Department of Planning and Environment

14 April 2022

**Moss Vale Plastics Recycling Facility (SSD-9409987)
Request for Additional Information**

Figure 2.1 Water balance diagram for the proposed facility

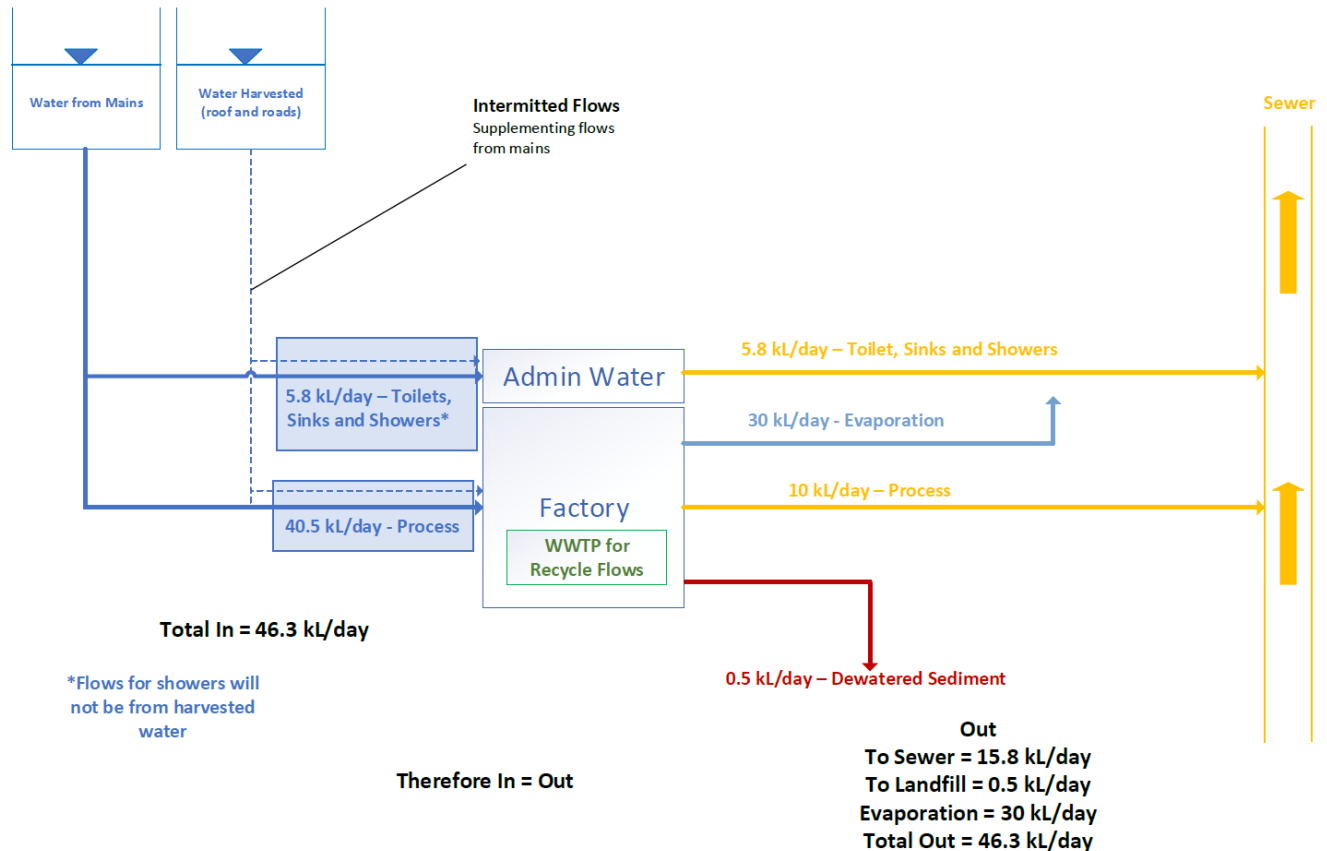
- The water balance shows 30KL/d is lost to evaporation clarify at what point in the process this occurs and whether it is captured via an emission control system.

Figure 4.2 5 year wind rose at Moss Vale AWS BoM station

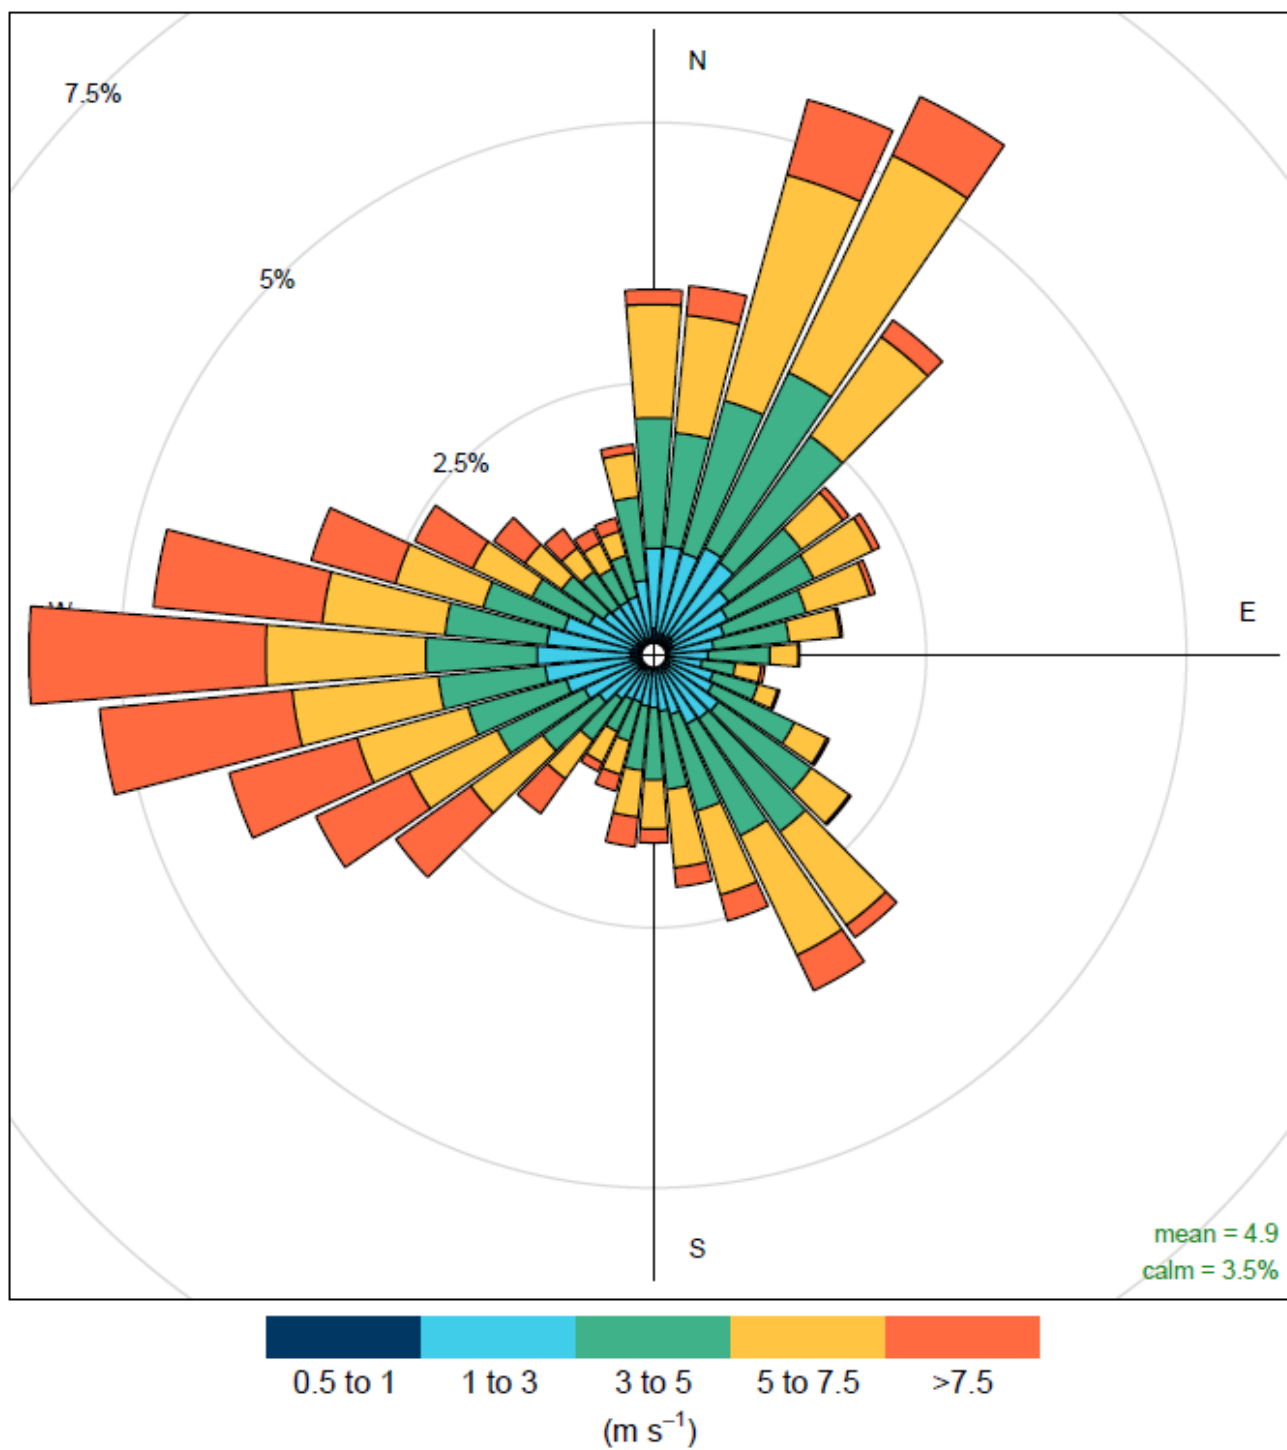
- Section 5.3.3 of the Air Quality and Odour report (AQOR) states that *'The majority of residential receptors are to the south of the proposal with the closest located to the southeast. The wind rose presented in Figure 4.2 shows winds in the direction of these receivers, from the northwest, are rare.'* The wind roses show significant wind from the northeast and west. Please clarify the likely impacts of these winds on residential receptors.
